**WEST SUSSEX COUNTY COUNCIL
PLANNING SERVICES CONSULTATION**

SUBJECT: LU/287/17/PL - Demolition of existing buildings, change of use & erection of 1 No. building incorporate office (B1) at ground floor & 8 No. dwellings at first floor level. Amendment received.

46a & 47, Pier Road & Land north of Clifton Road, Littlehampton, BN17 5LW

drawing **Proposed site plan**

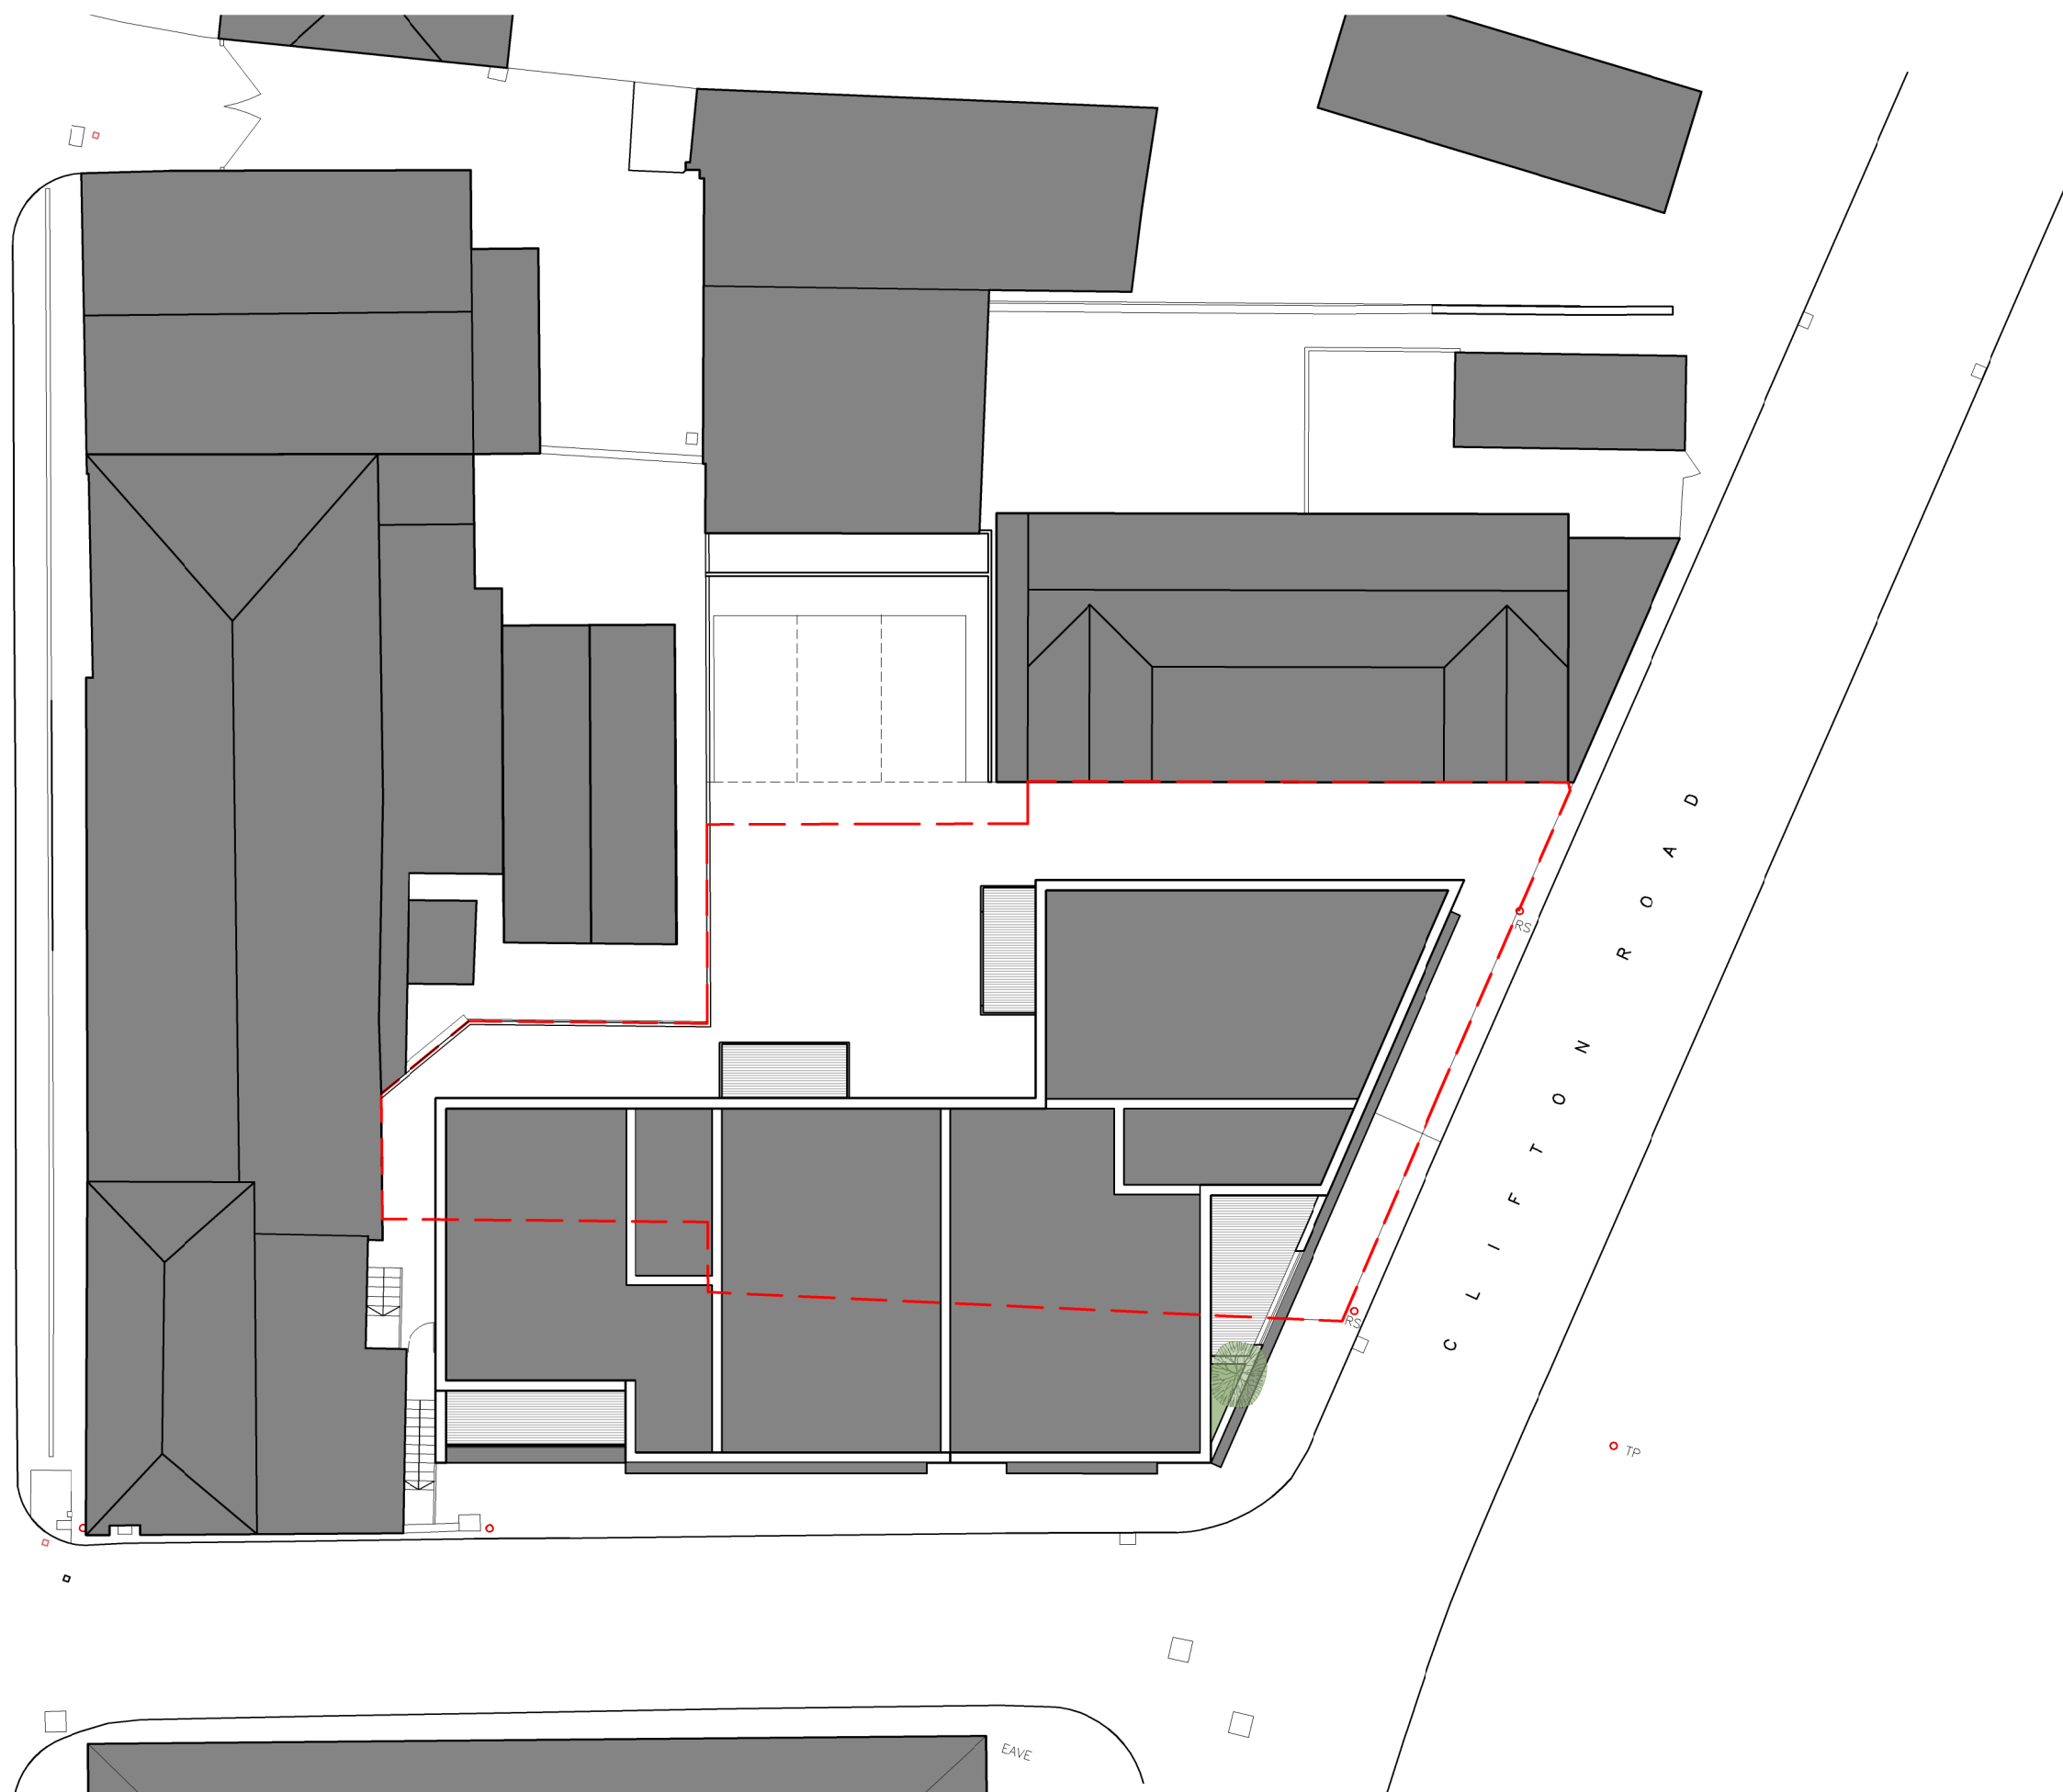
A total of eight car parking spaces are now proposed, however the applicant has not clarified whether these will be of an unallocated arrangement or allocated to particular flats. The layout of these has been altered in order to provide a wider undercroft vehicle access into the site. Whilst two cars can pass within the site the access opening where it meets the public highway is approximately 4.3m wide. This was previously advised to be 4.5m to allow two cars to pass at the entrance. The applicant should therefore demonstrate via swept path tracking diagram that two cars can pass within the entrance.

The full extent of the proposed works including access are cut off from the plan and should be provided along with demonstration of achievable vehicle visibility splays. The LHA would consider that a 2m 'X' distance would be suitable in this location and splays should be taken to the nearside carriageway or at a 1m offset from the road edge.

The LHA appreciate the improvement in the vehicle access route which allows two cars to pass within the site. Nevertheless, spaces seven and eight would still result in possibility of a car reversing and exiting onto Clifton Road between the supporting wall of undercroft parking and neighbouring property with limited visibility. The

applicant could consider blocking space 8 in and having the two tandem spaces allocated to one flat with the remaining six spaces being of an unallocated arrangement. This would result in all cars exiting from the same point where there would be an improved vehicle visibility splay.

In summary the applicant should consider allocating the tandem spaces to a single residential unit and confirm whether the remaining parking spaces will be unallocated. On this basis the parking provision will meet the anticipated demand as per the WSCC Car Parking Demand Calculator. This will then enable the applicant to demonstrate achievable vehicle visibility from 2 m back into the proposed access point, extending to the nearside carriageway edge in either direction. The width of the proposed access point will also allow for some level of pedestrian visibility. The applicant should also provide a swept path of two cars passing within the access to demonstrate the achievability of this; alternatively the access could be widened to 4.5m.
